Item No. Report of the Interim Director of Planning, Regeneration & Public Realm

Address: VICTORIA ROAD SERVICE STATION VICTORIA ROAD RUISLIP

Development: The demolition of fuel pumps and the creation of charging zone, erection of EV chargers, sub-station enclosure and associated forecourt works.

LBH Ref Nos: 4254/APP/2023/106

DRAWN BY	DATE	SCALE	PAPER SIZE
PT	21.04.2022	1:100	A1
CHECKED BY	DRAWING NUMBER	REV.	
RB	13664-P02-656	D

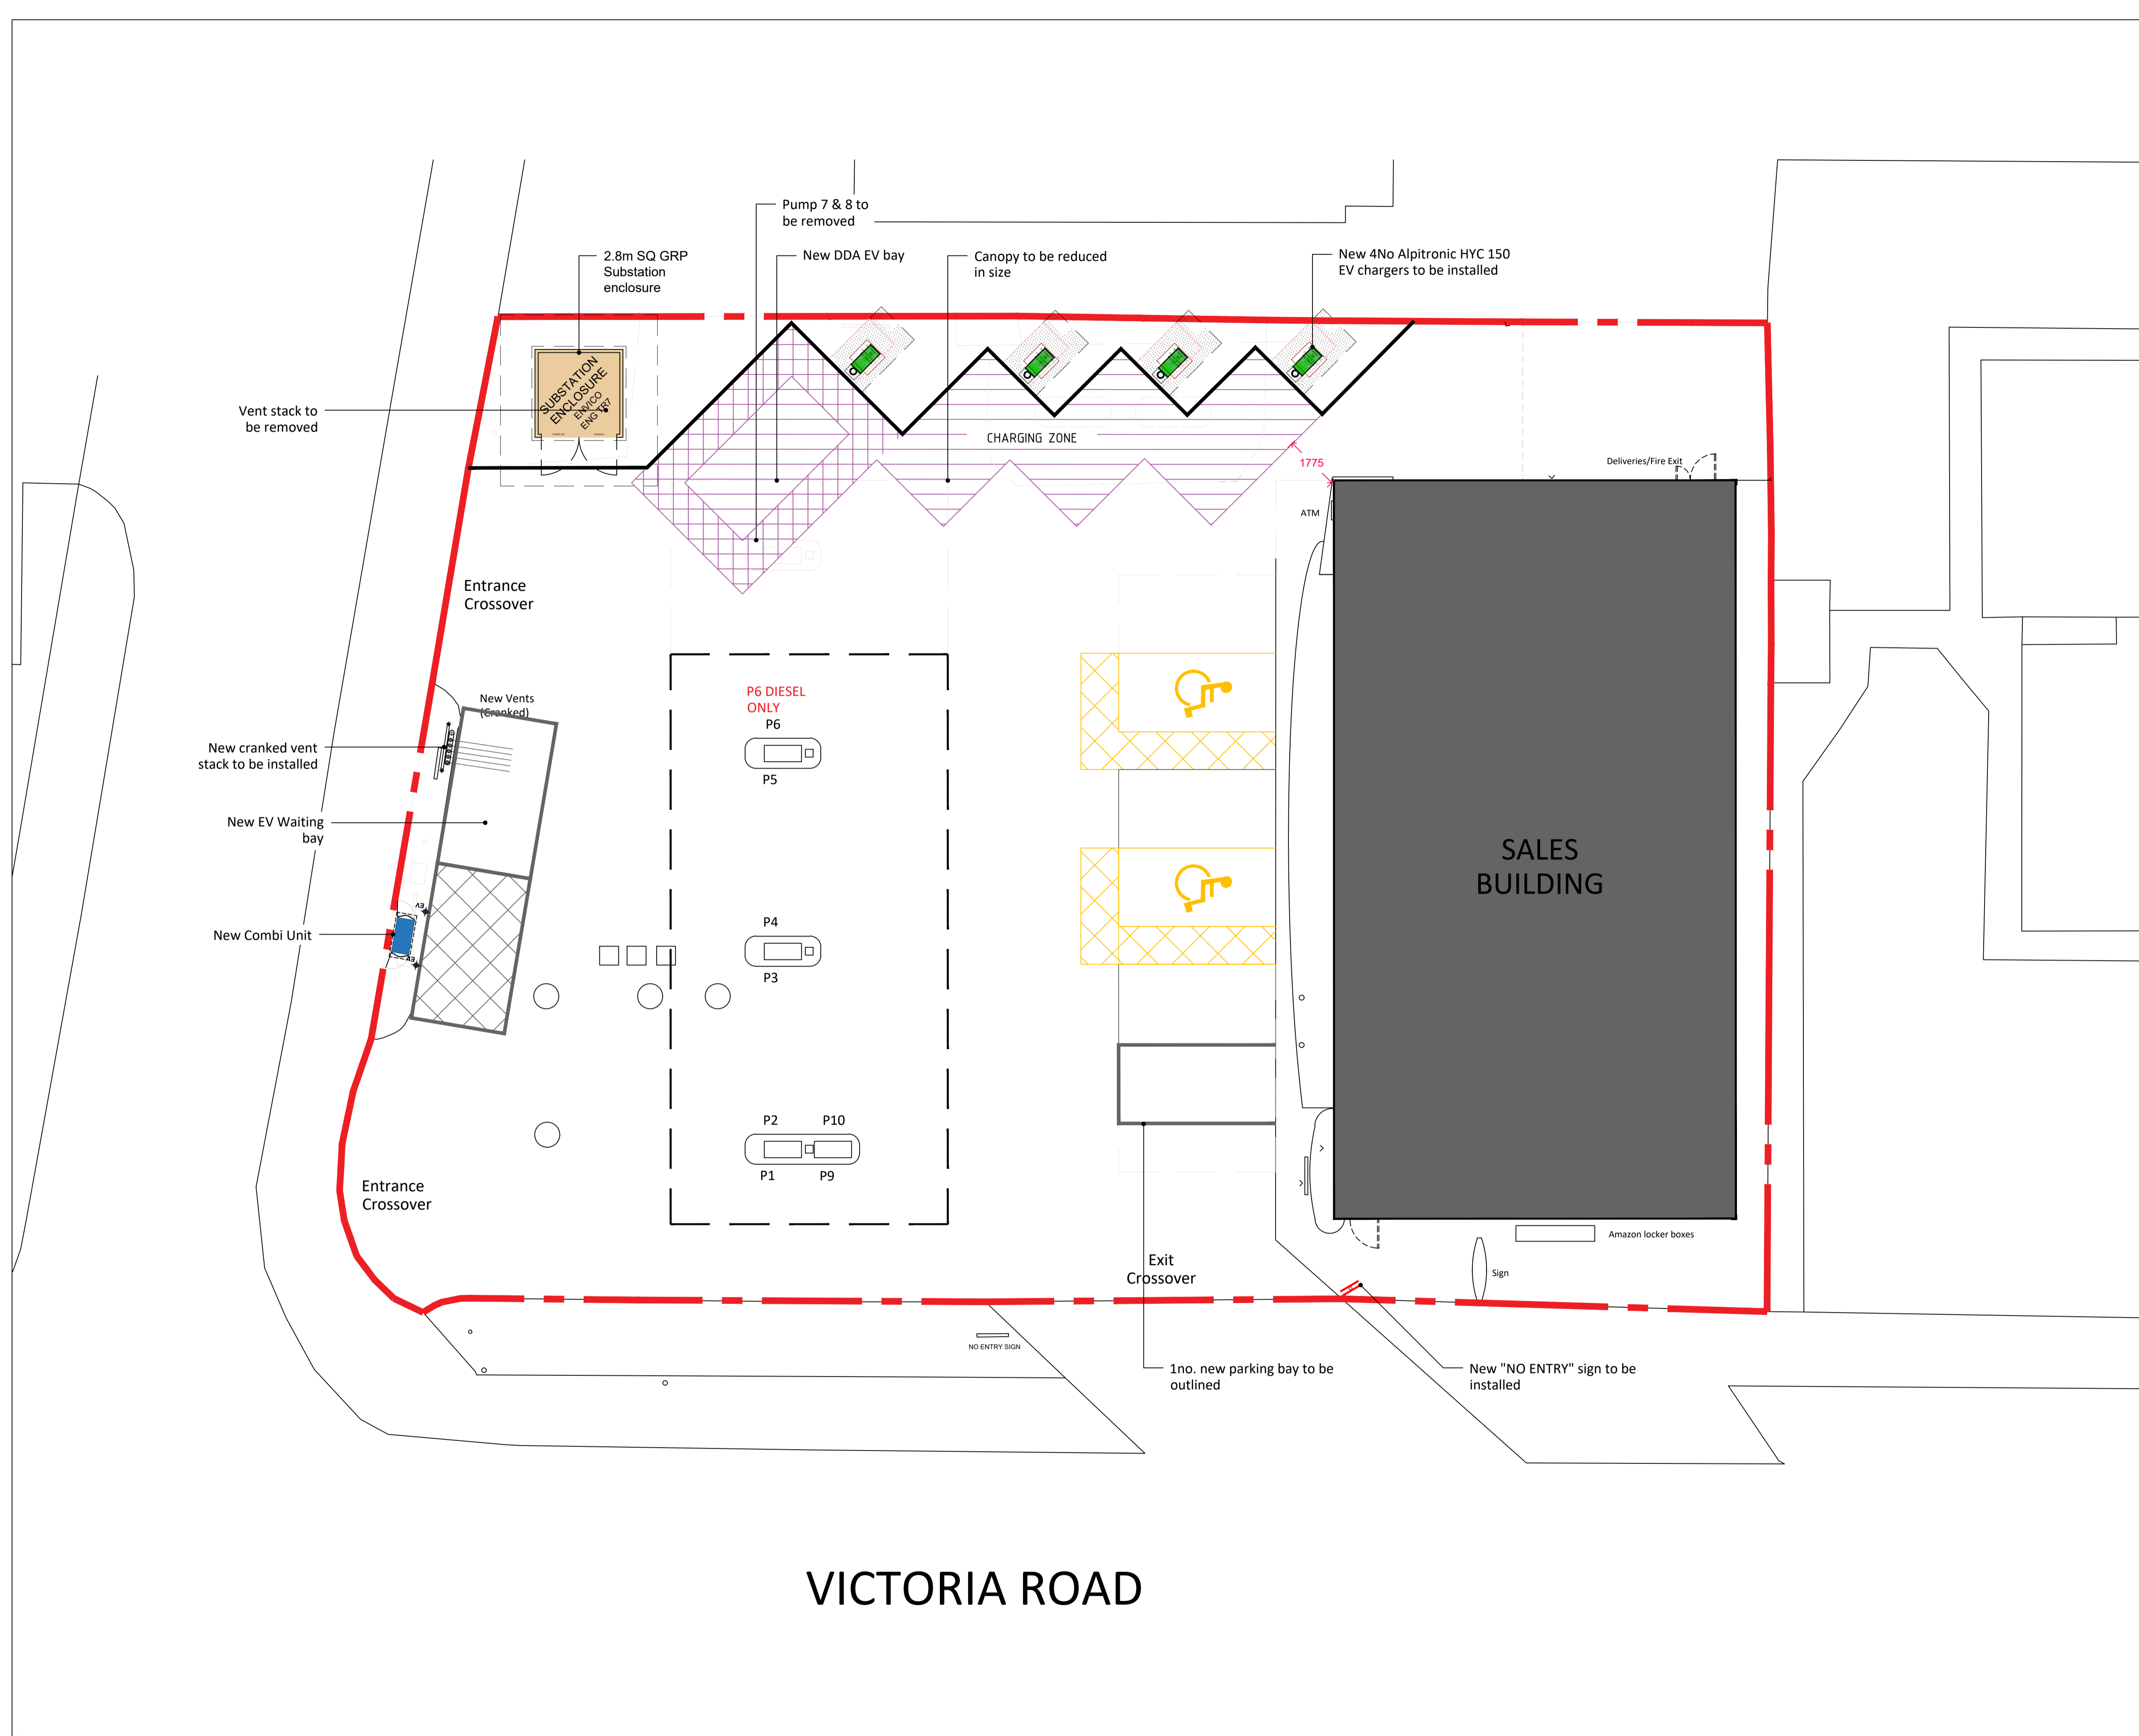
- Existing Site Plan no. 13664-P01-656 revB. The only change here is to label the existing 'No Entry' sign adjacent to the exit.
- Proposed Site Plan no. 13664-P02-656 revE. This plan shows
 - An additional No Entry sign adjacent to the exit
 - A new EV waiting bay, adjacent to the Air/Vac space
 - A new DDA compliant EV bay, complete with a 1200mm transfer zone to both sides and rear of the bay.
- EV Charger Detail plan no. 13664-P03-656 revA. This shows the screen and charger cable to be between 800mm and 950mm above ground level.
- The substation has been moved further into the site.

Further to the accessibility comments provided on 24/01/2023 and revised plans received 28/03/2023, no further concerns are raised subject to the following condition attached to any approval: The electric vehicle charging points hereby approved shall ensure that a minimum of one charging point is fully accessible to wheelchair users and people of short stature, in accordance with BSI PAS 1899:2022, which shall remain in place for as long as charging facilities remain on-site. REASON: to ensure an inclusively designed environment in accordance with London Plan policy D5.

In response to earlier highway comments the application has been amended to include a car parking space for EV drivers to use until an EV charge point becomes available. The Highway Authority welcomes this change but requires that this space is either signed or lined "For Electric Vehicle Use Only". There are no highway objections to this proposal subject to a planning condition

The electric vehicle waiting space shall be either signed or lined "For Electric Vehicle Use Only".

The electric vehicle charging points hereby approved shall ensure that a minimum of one charging point is fully accessible to wheelchair users and people of short stature, in accordance with BS1 PAS 1899:2022, which shall remain in place for as long as charging facilities remain on-site.

DRAWING TITLE  
SUBSTATION ELEVATIONS

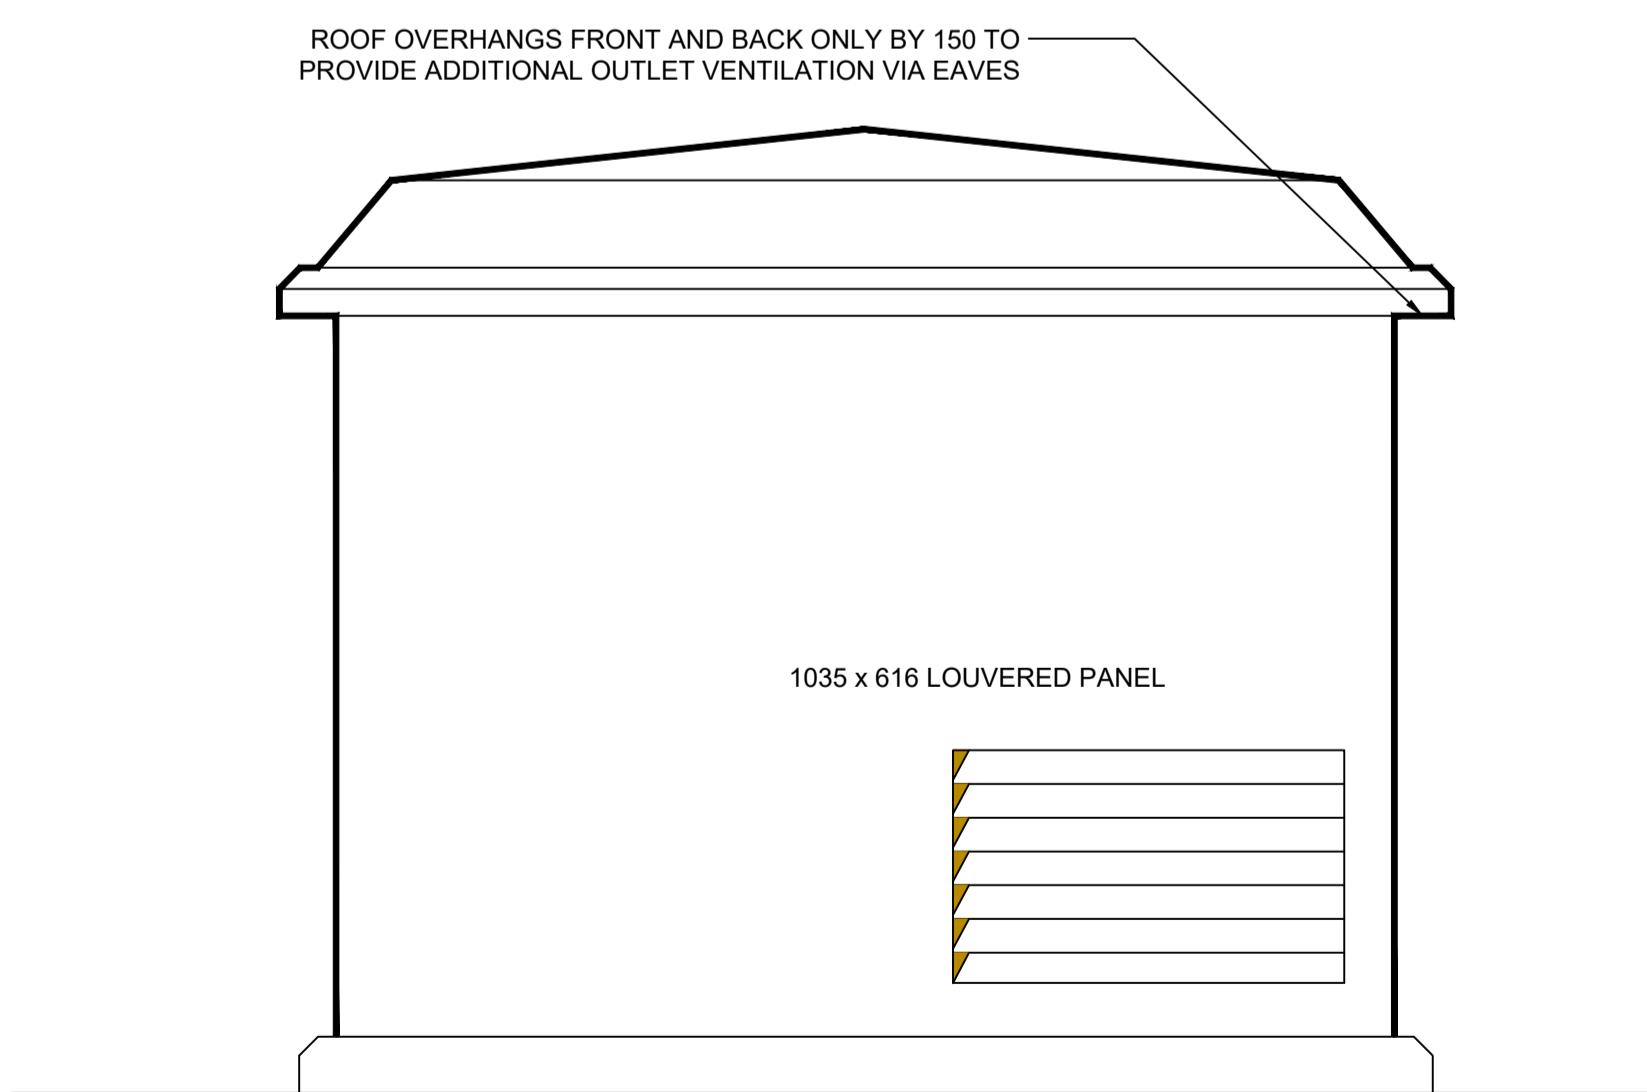
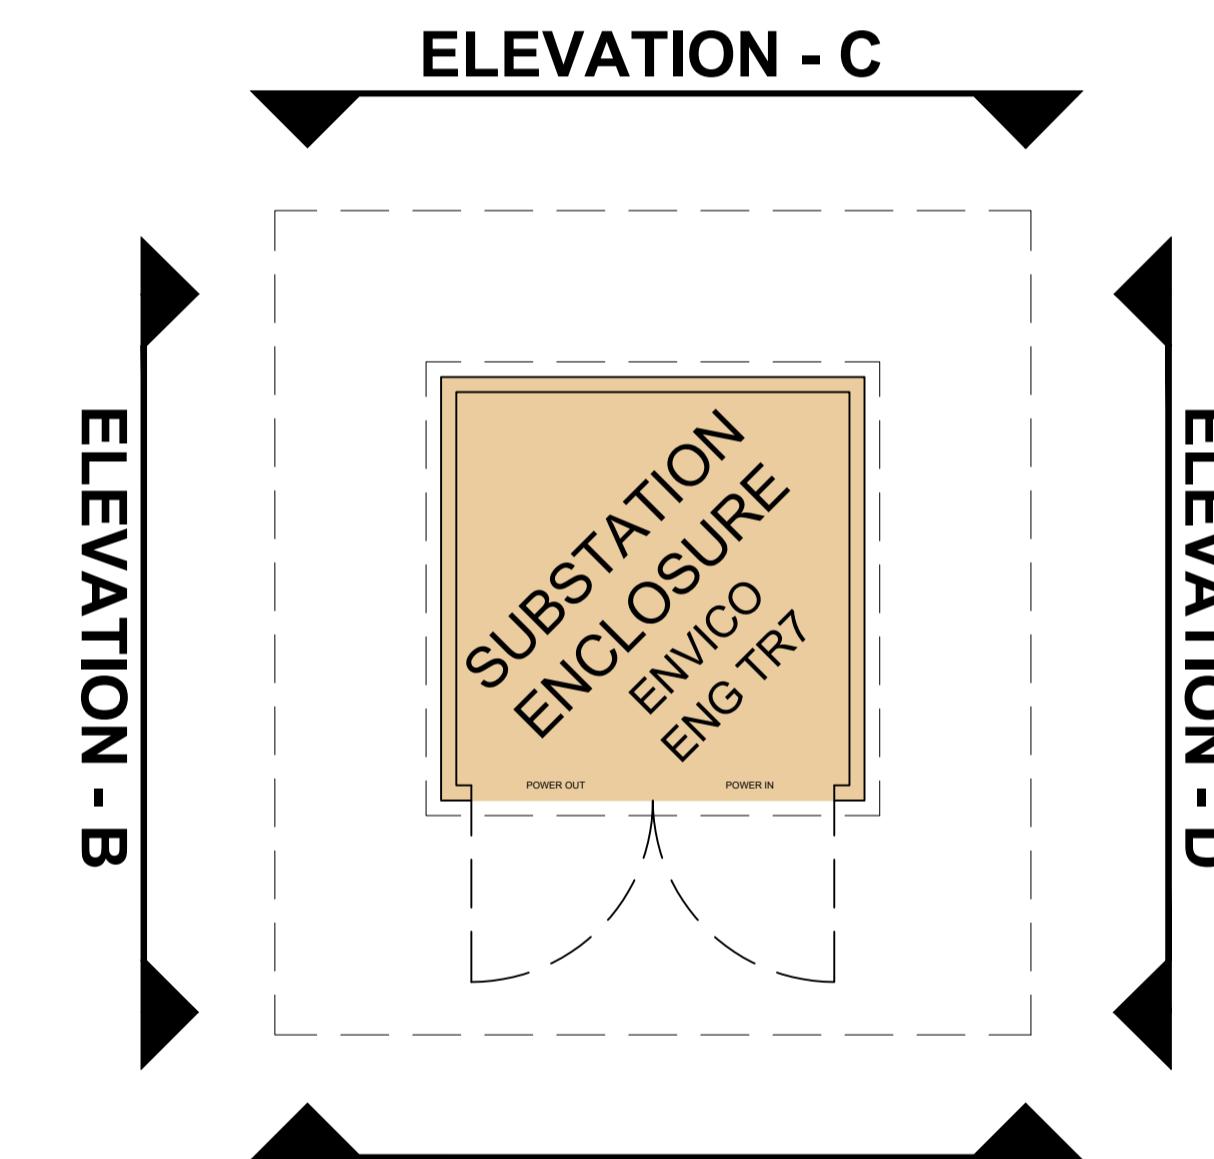
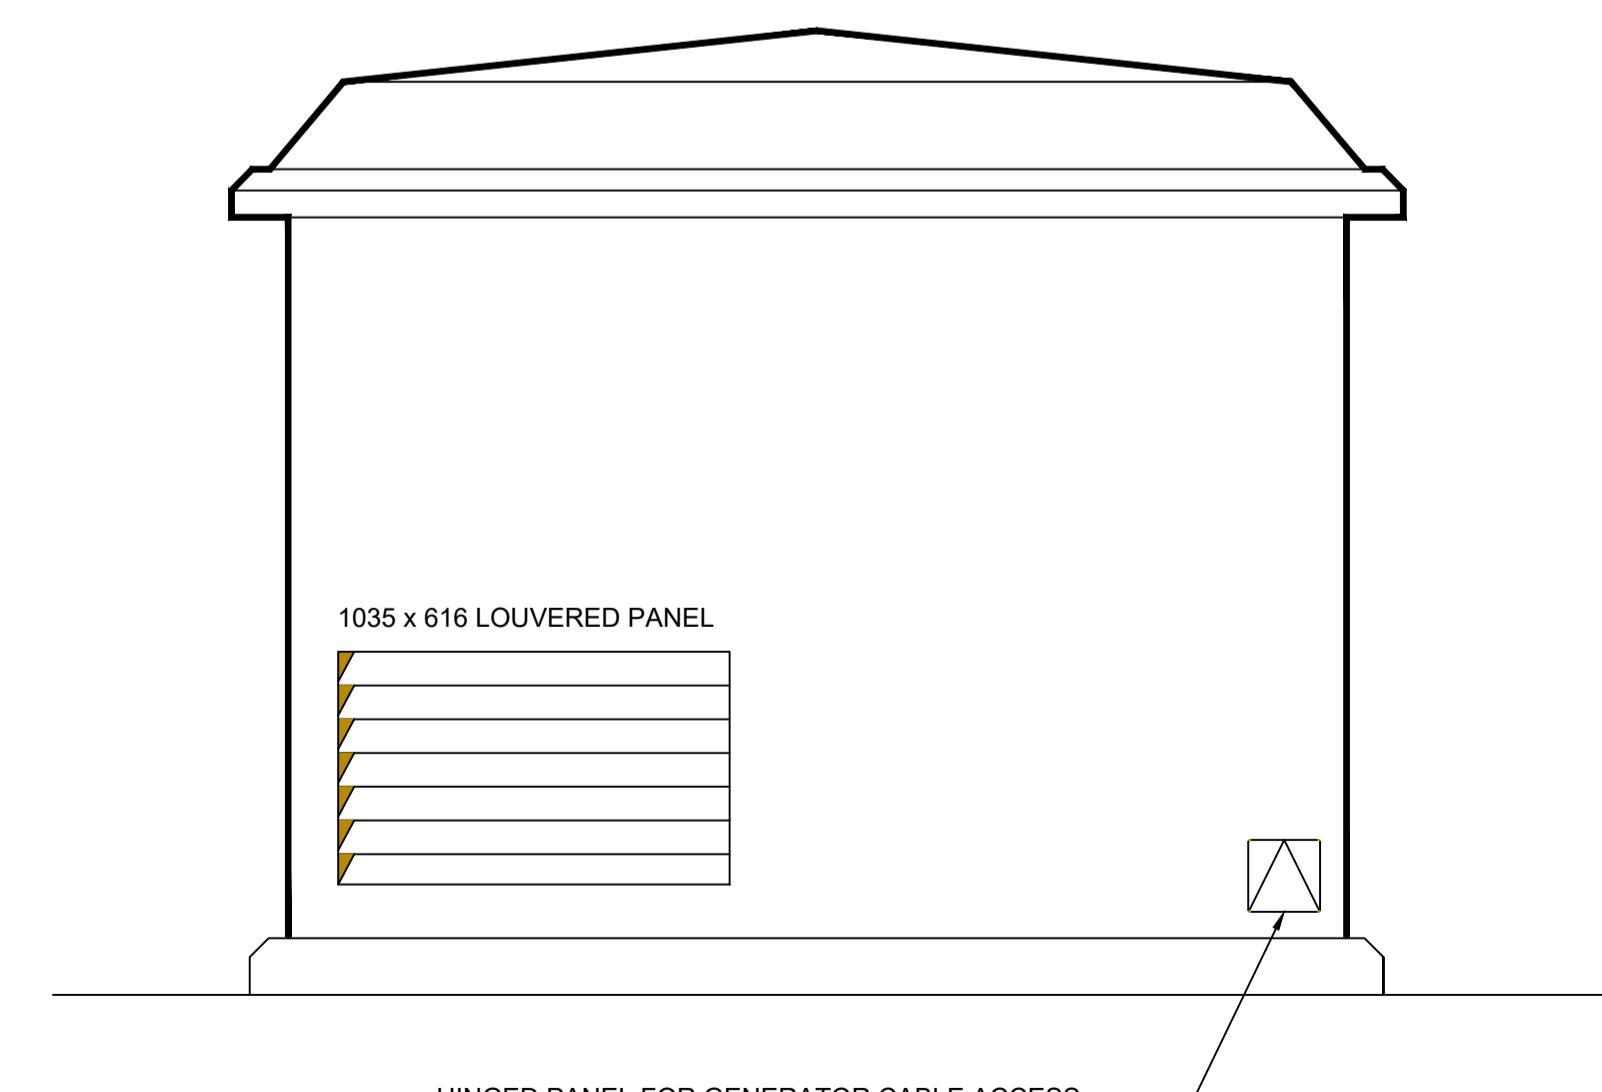
In addition, a small GRP substation with enclosure is proposed to be sited towards the northeast corner of the site. The substation enclosure would have a height of 2.5metres and a width and depth of 2.8metres and would have a dark green colour exterior. The revised site plan has moved the substation into the site to ensure visibility of the neighbouring sign is not impacted on and without it impacting the parking bay.
